Application reference number	2025/0583
-------------------------------------	-----------

Proposal Description:	Erection of detached two-storey dwelling with associated access and garage.
Location:	Land adjacent St John the Evangelist Church, Carlton Road, Carlton, Barnsley.

Recommendation: **GRANT Planning Permission**

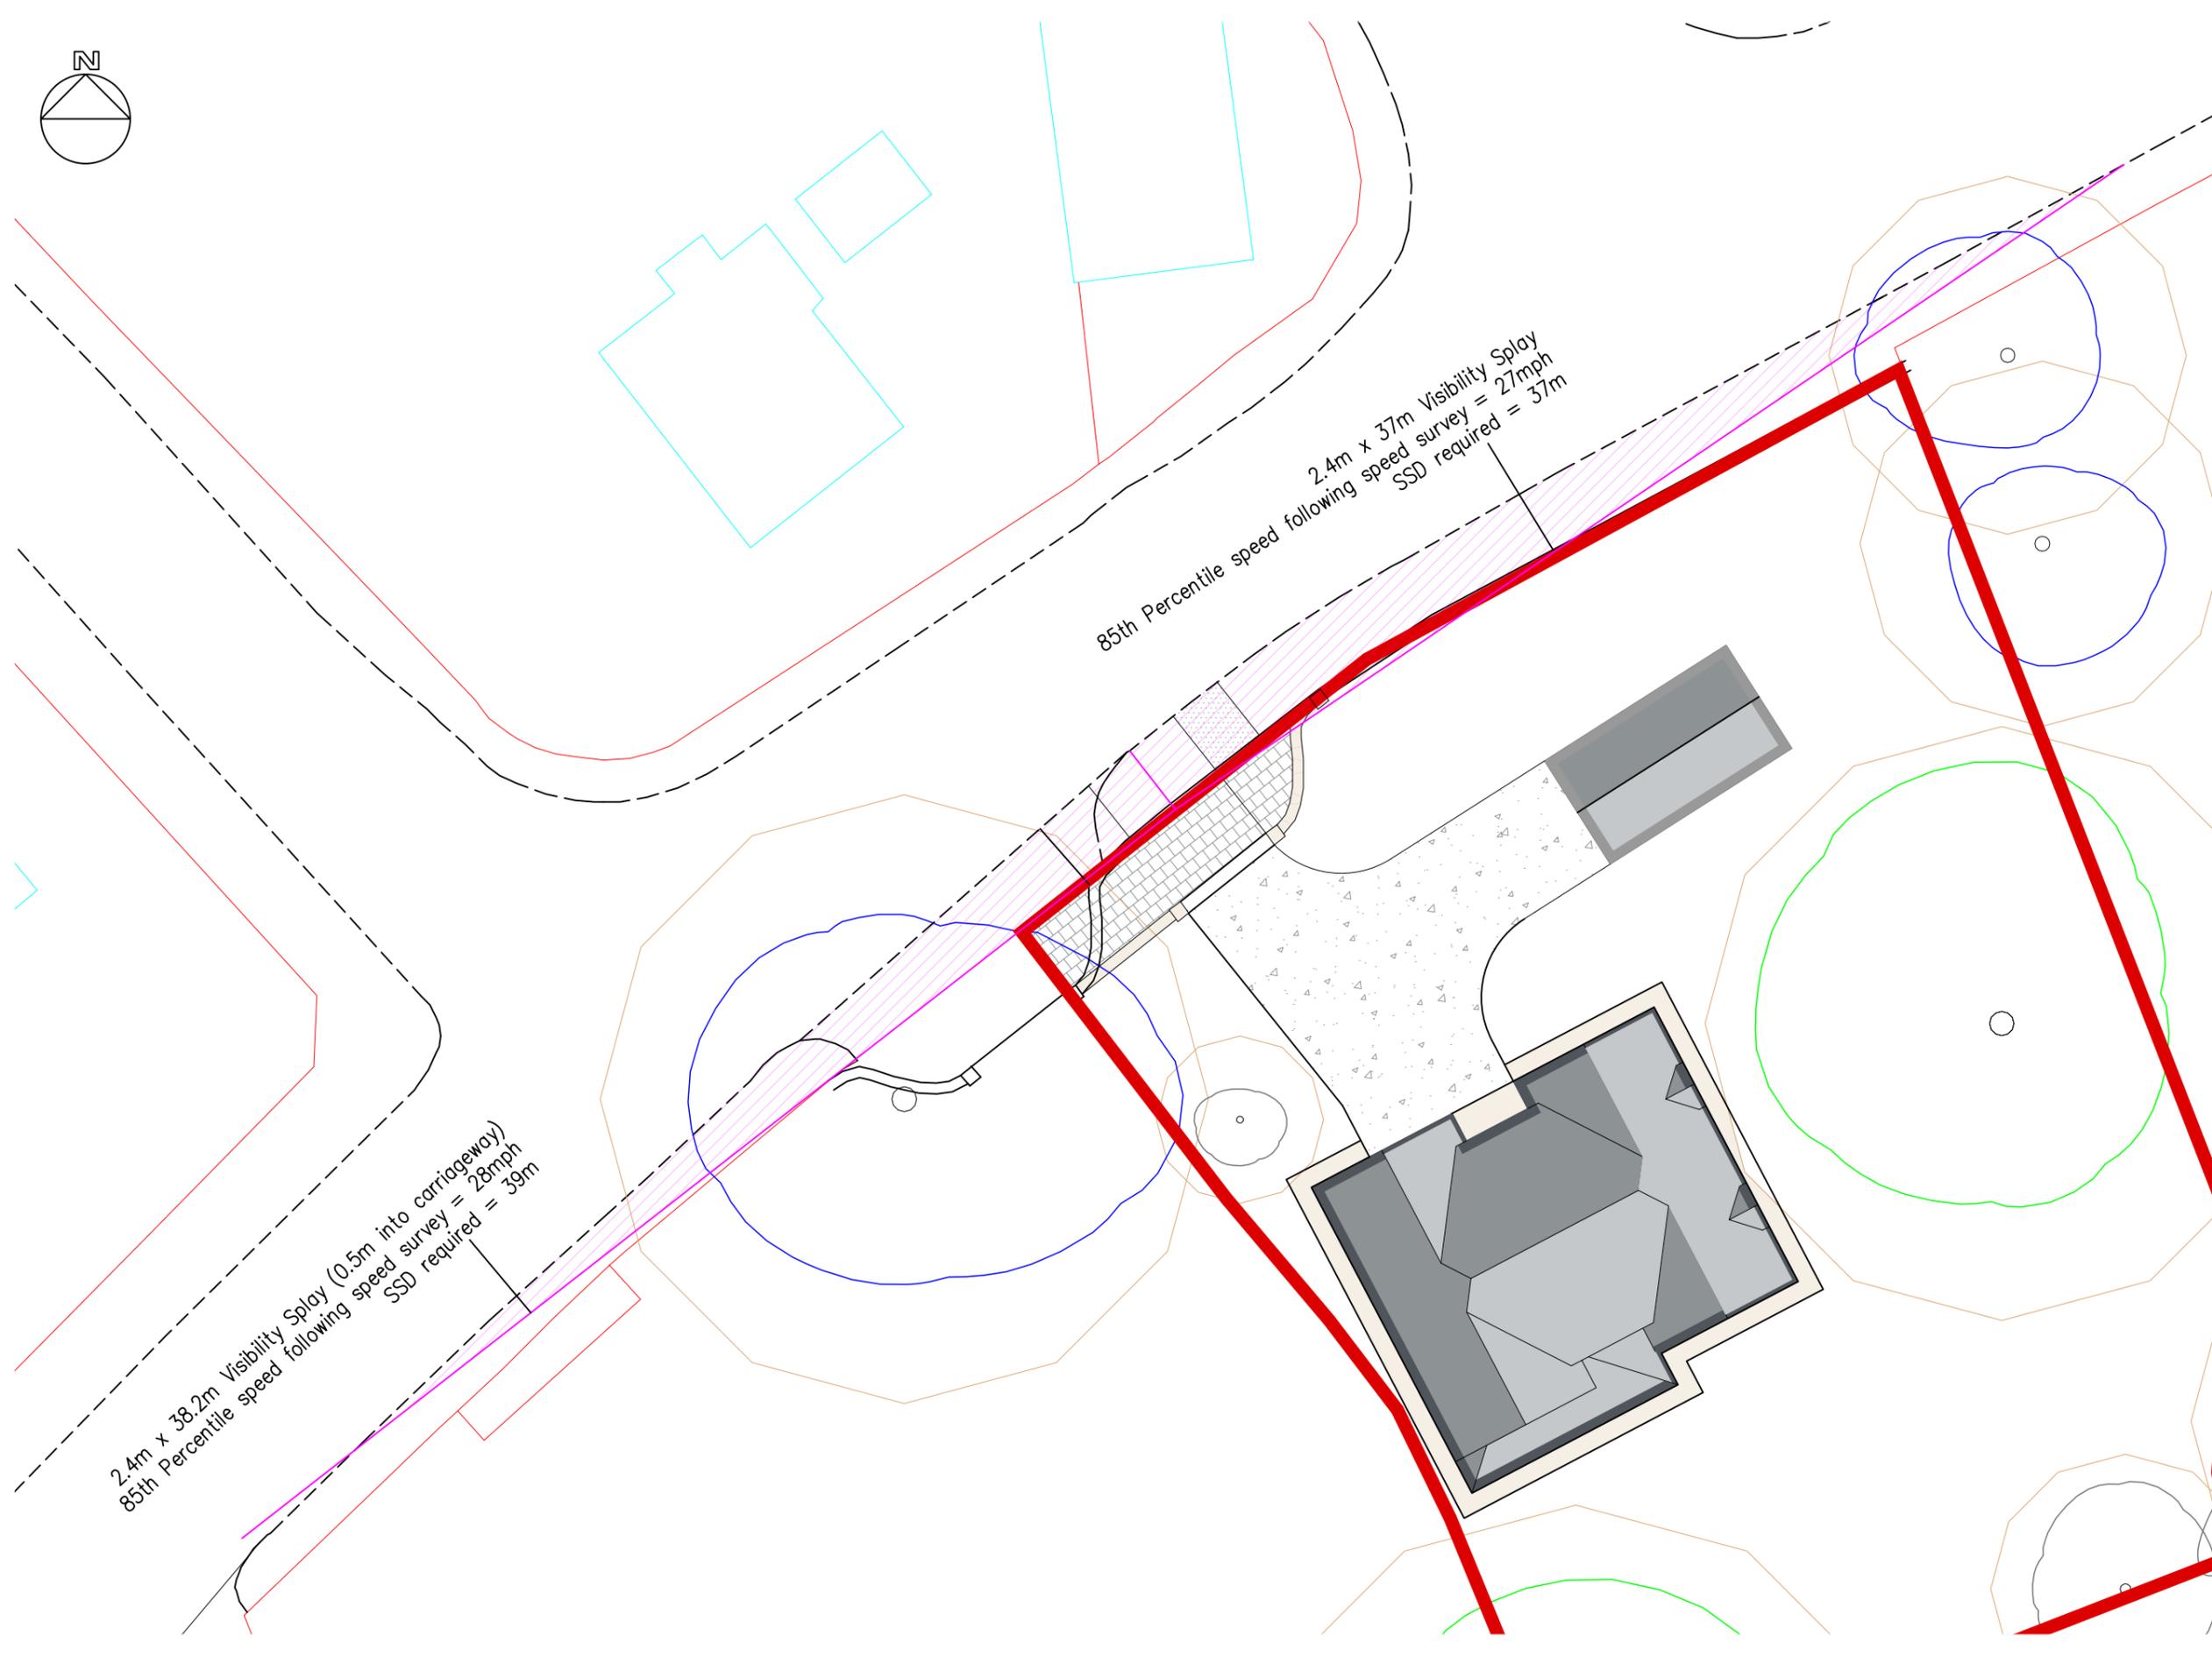
The proposal involves the creation of an access onto the classified road and plans outlining the visibility splays have been provided. It is acknowledged that the visibility splay to the west encroaches into the carriageway, however, it is in the channel of the lane of traffic moving away from the site and the splays are commensurate with the 85th-percentile speeds measured by way of an independent speed survey. This carries significant weight in favour of the application.

To address the initial concerns raised by highways in terms of a suitable access to a classified road.

Highways DC have been consulted on the application, and they raise no objection to the development or the introduction of the access onto B6132 Carlton Road, subject to conditions

NORTH ELEVATION

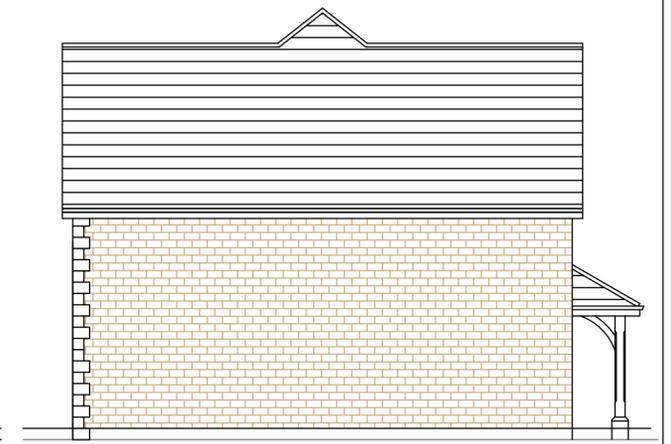
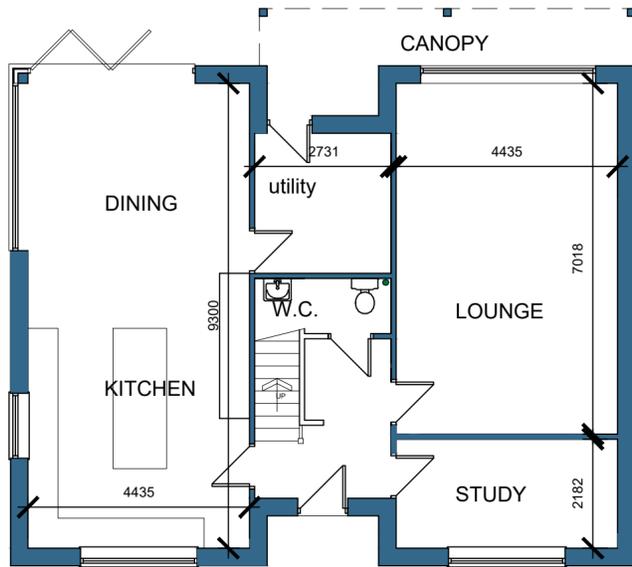
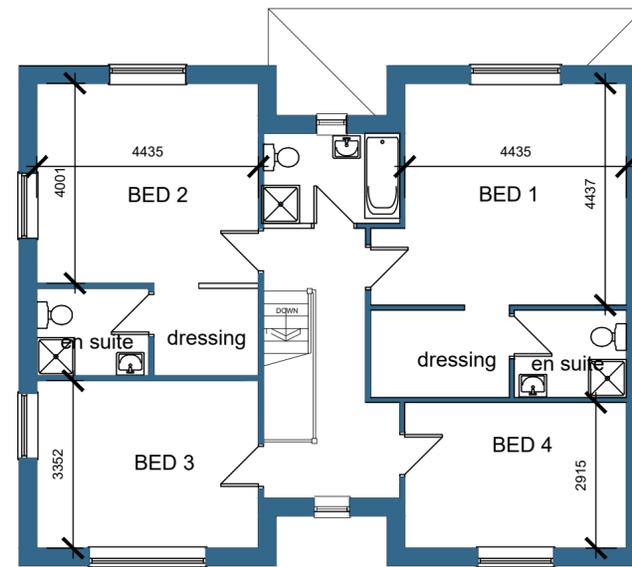
The proposed dwelling will be seen in close context with the church and the Gables (to an extent) and as such, from a conservation area perspective and a group value standing, the development along this stretch of Carlton Road will be considered together. The design of the house has relatively steeply raked gables and mullioned windows which reflects elements of style from The Gables; the use of timber framing around the rear canopy, and the use of quoins are noted and welcomed.

The heritage statement notes the use of 'stock brick' to imitate the stone in buildings nearby. The Conservation Officer would suggest stone not brick represents the typical historic material and is present in the buildings that contribute the most to the conservation area and its group value. The bulk of the buildings in the immediate vicinity including the listed Church and The Gables are in stone and so coursed (split or pitched face) stone with ashlar dressings is the most appropriate material for the walls of the proposed dwelling. Therefore, a condition requiring details, along with a representative sample, of materials to be submitted for approval will be included.

PROPOSED BOUNDARY TREATMENTS

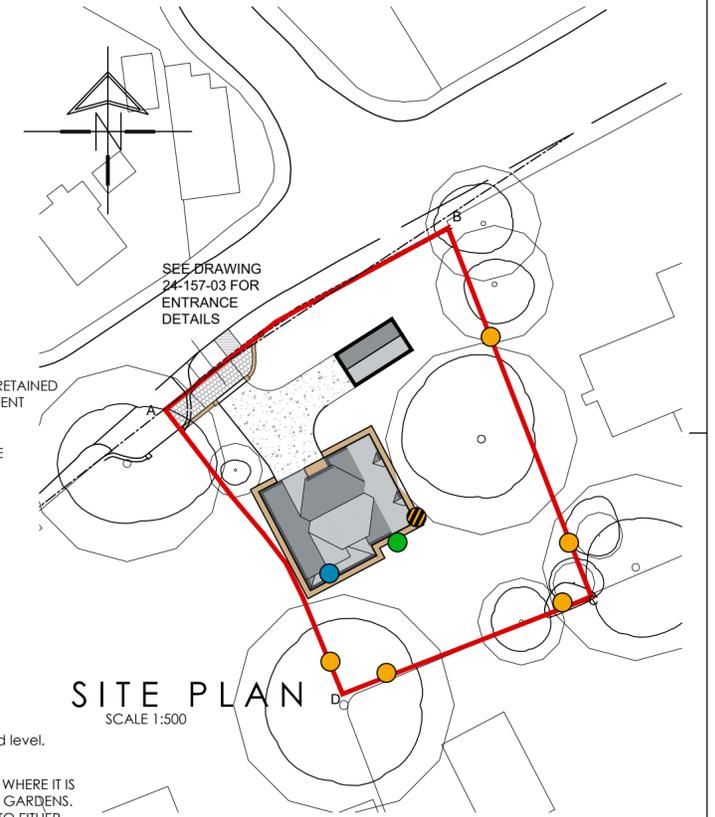
Concerns have been raised in relation to the feather edged 1800 timber fencing along the eastern boundary of the site with St Johns Church. This appears extremely modern and utilitarian and is not especially sympathetic to the setting of the church. This could easily be softened with other materials and fence types that complement the setting more effectively or supplemented with native planting including shrubs and trees that enhance the screen between the plot and the church to the east. It is considered that an updated boundary treatment along the eastern boundary can be secured by a planning condition.
